Alan Cadogan - MP 09_0066 MOD 6 - Chatswood Albert Ave/Thomas St Development Concerns

From: "Loveday, Mike, Vodafone Group" <mike.loveday@vodafone.com>
To: <alan.cadogan@planning.nsw.gov.au>
Date: 2/05/2013 4:45 PM
Subject: MP 09_0066 MOD 6 - Chatswood Albert Ave/Thomas St Development Concerns

SHADOW DIAGRAM  
21 JUN

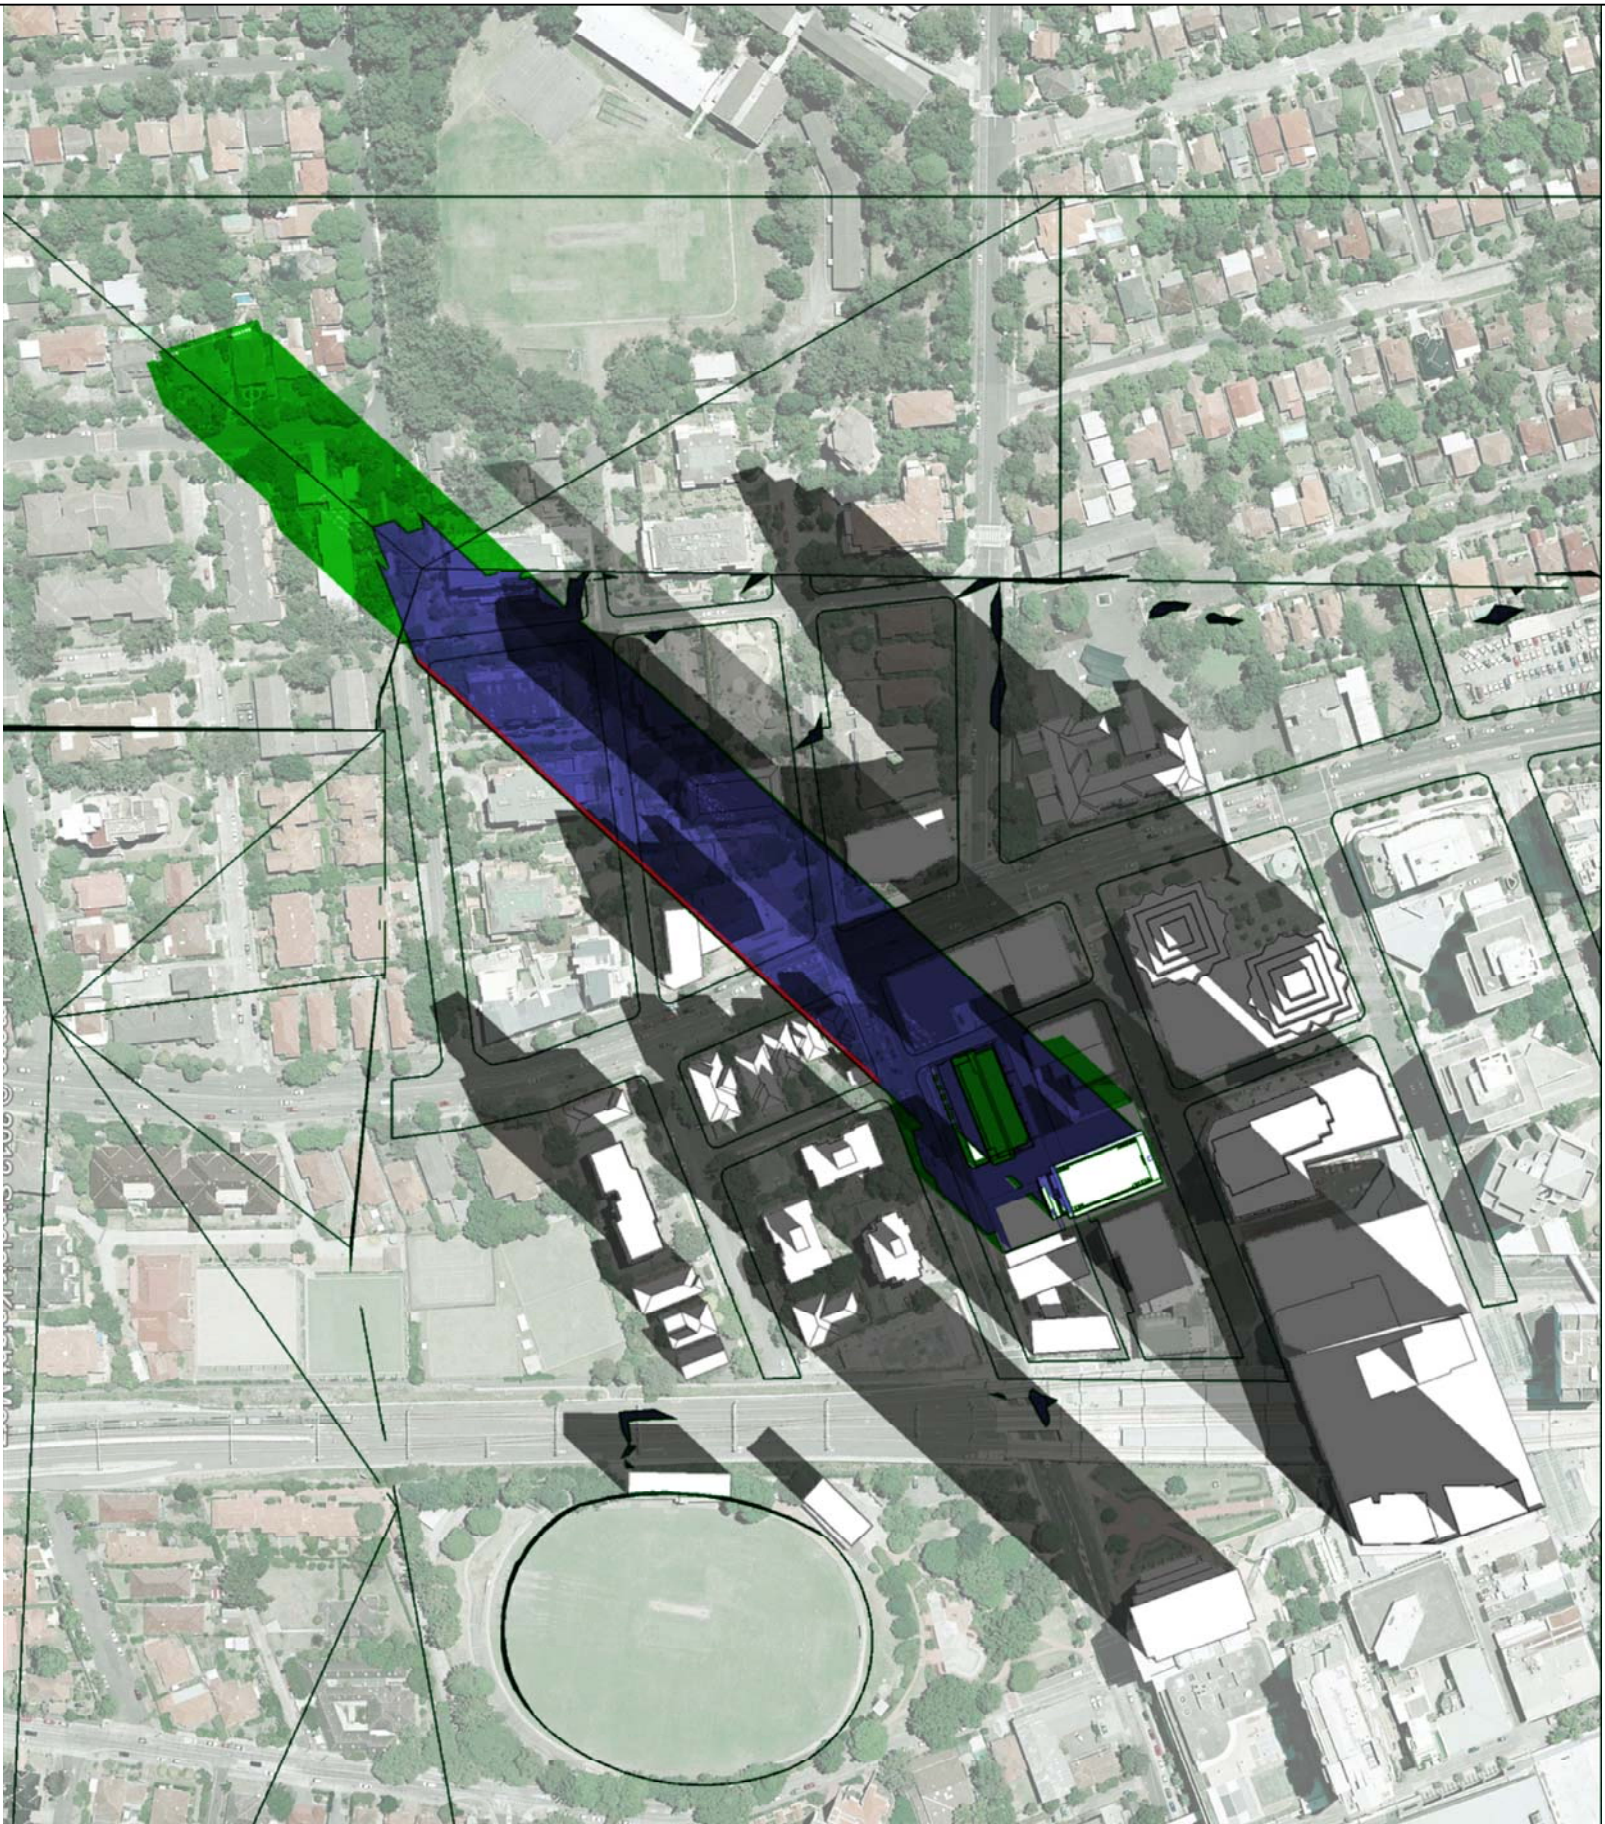
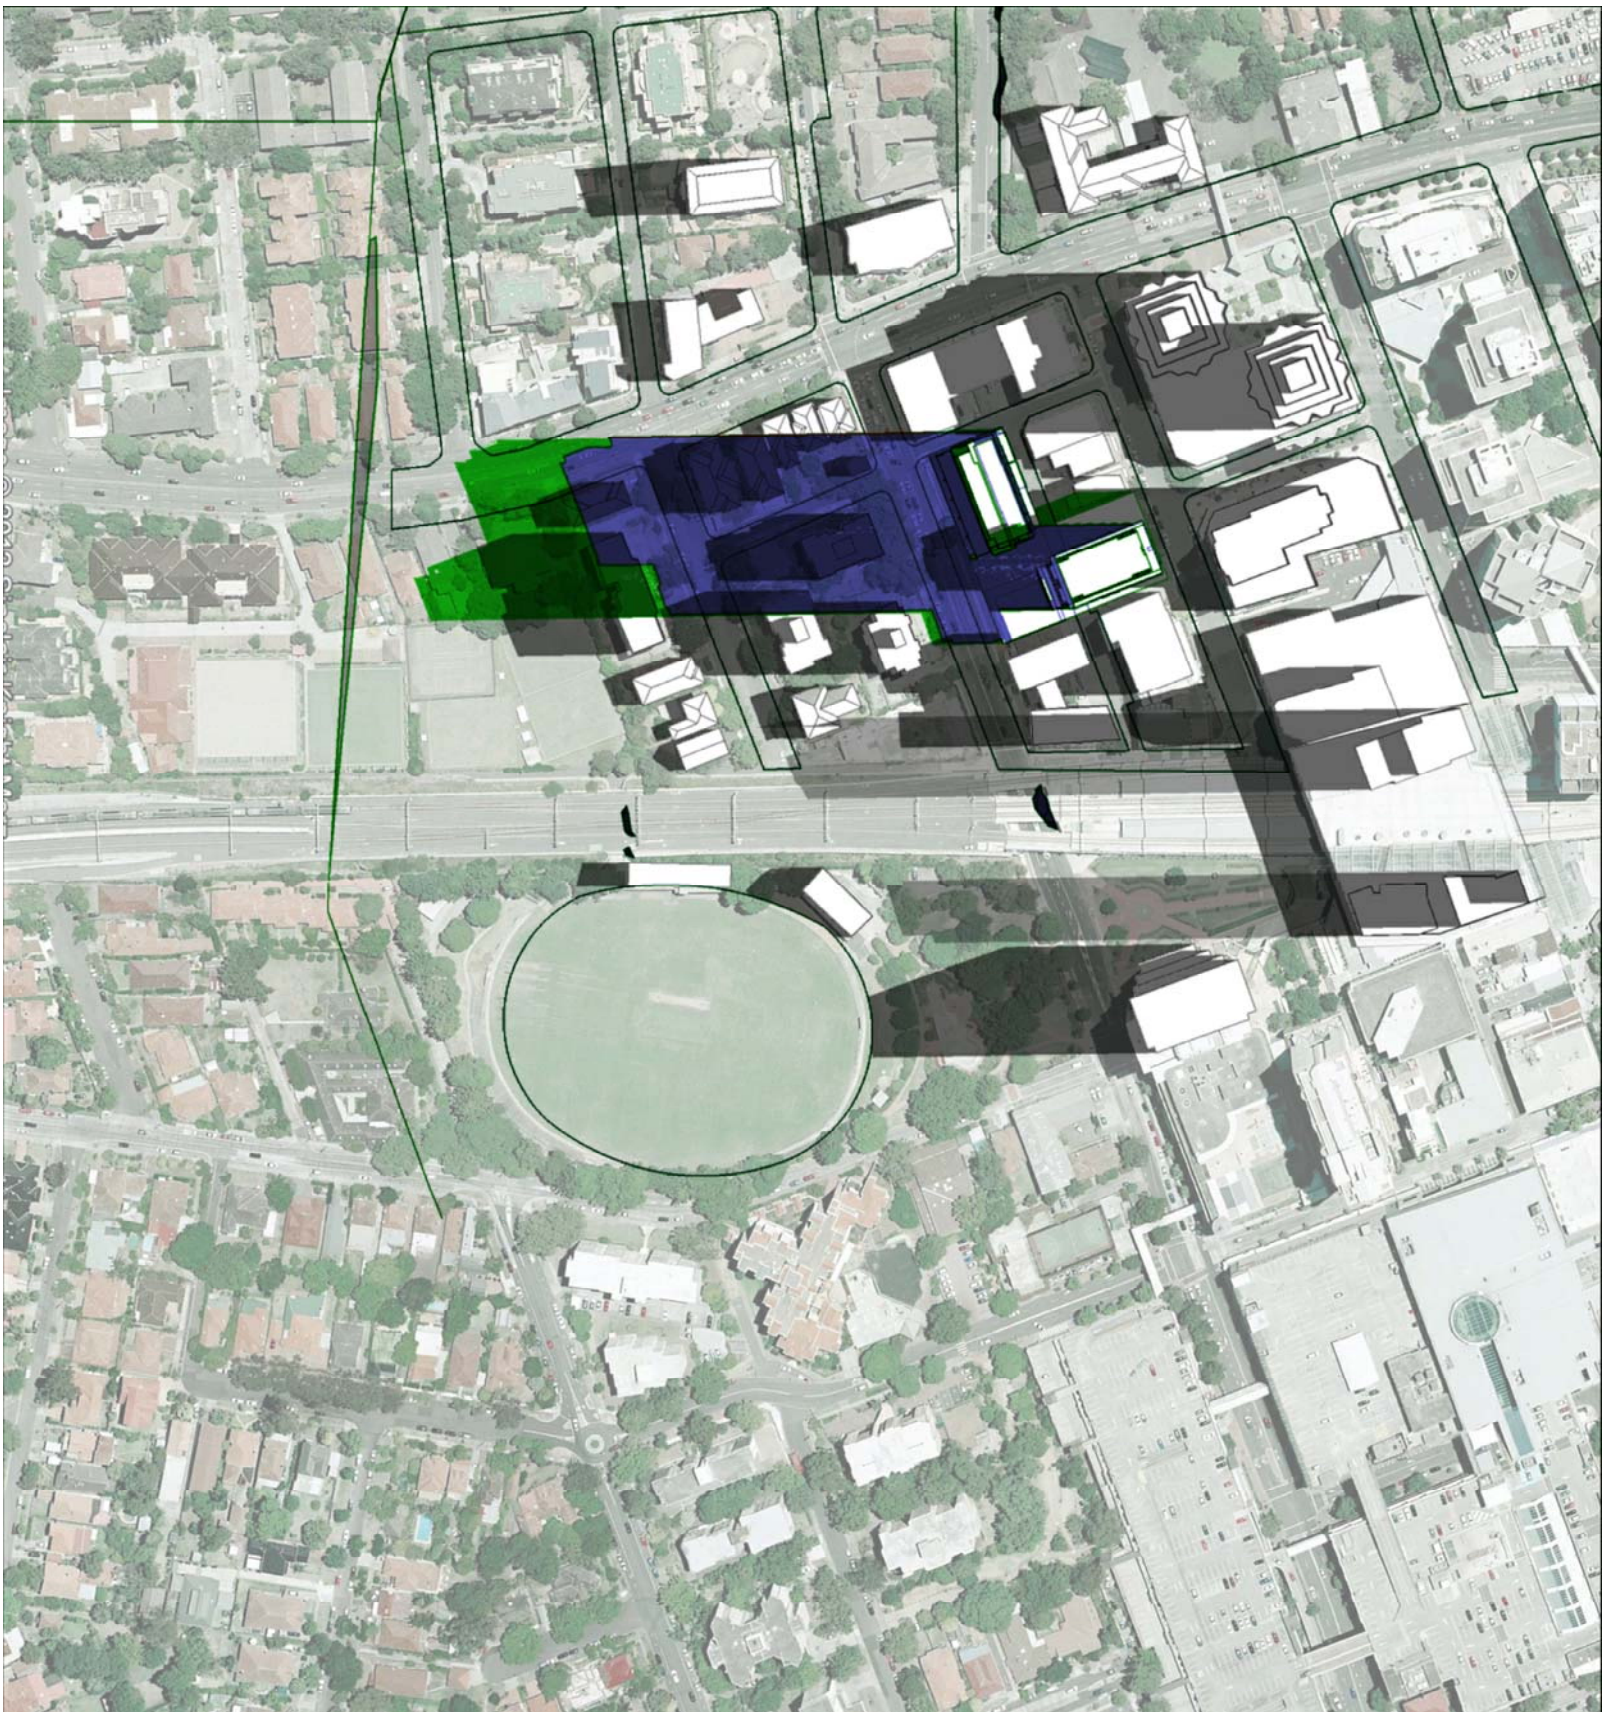
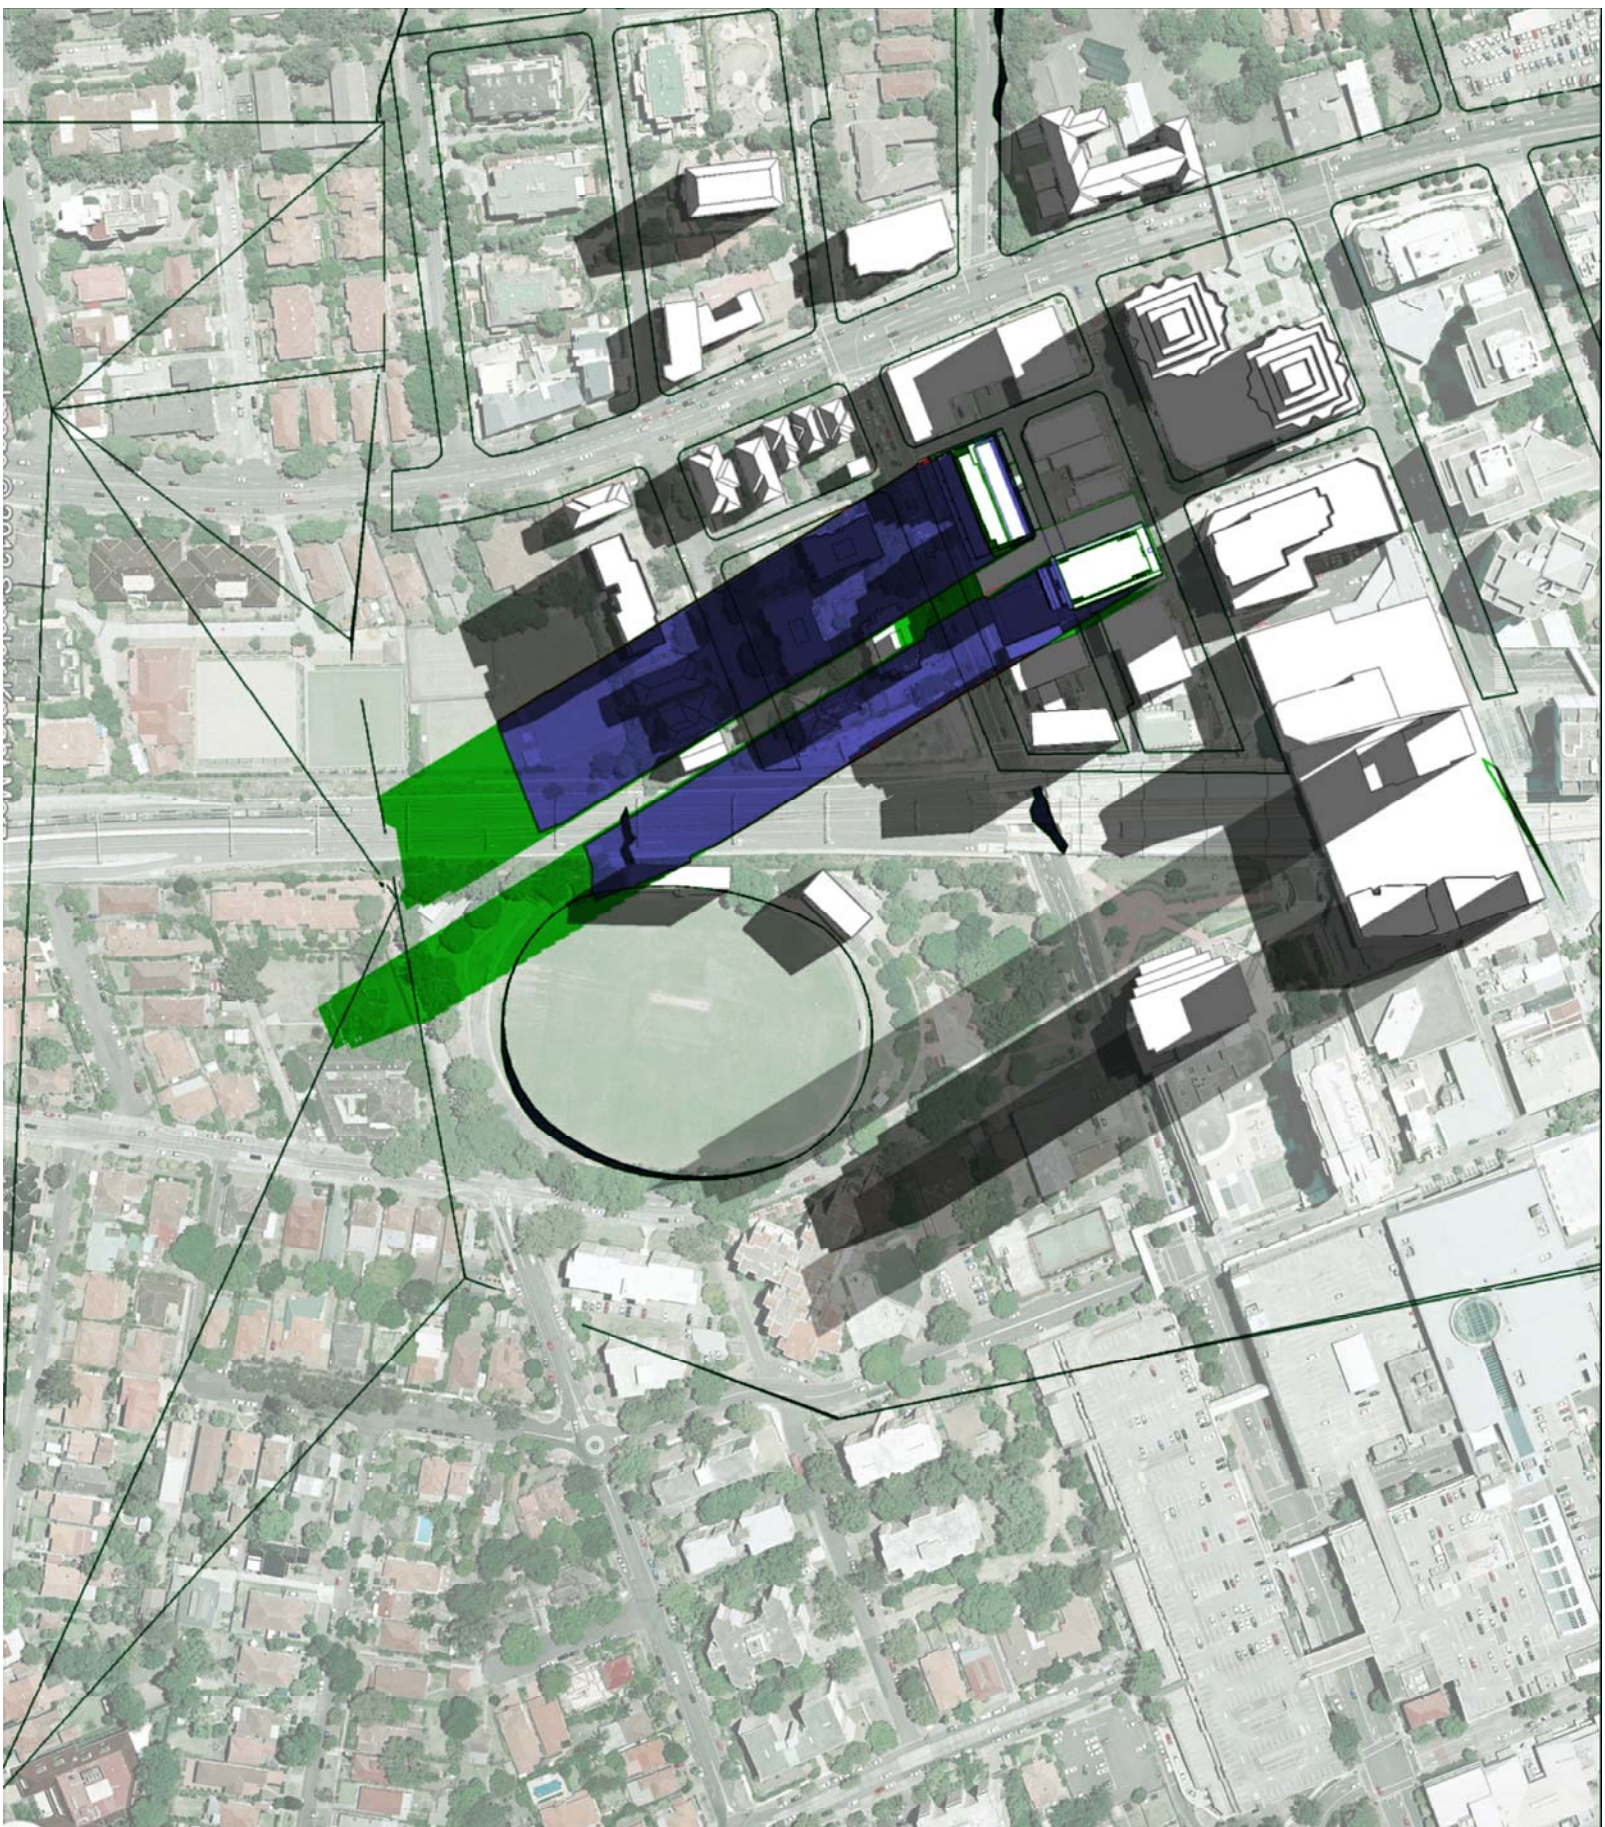
Massing Impact from the bulk form of Tower-2 as well as loss of solar access and shadowing will be further excessive given that this tower is longways across the site. Being a north facing rectangular bulk form, it will shadow the much smaller residential fringe to the south including the nationally prized Chatswood Croquet and Bowling Greens and Chatswood Oval.
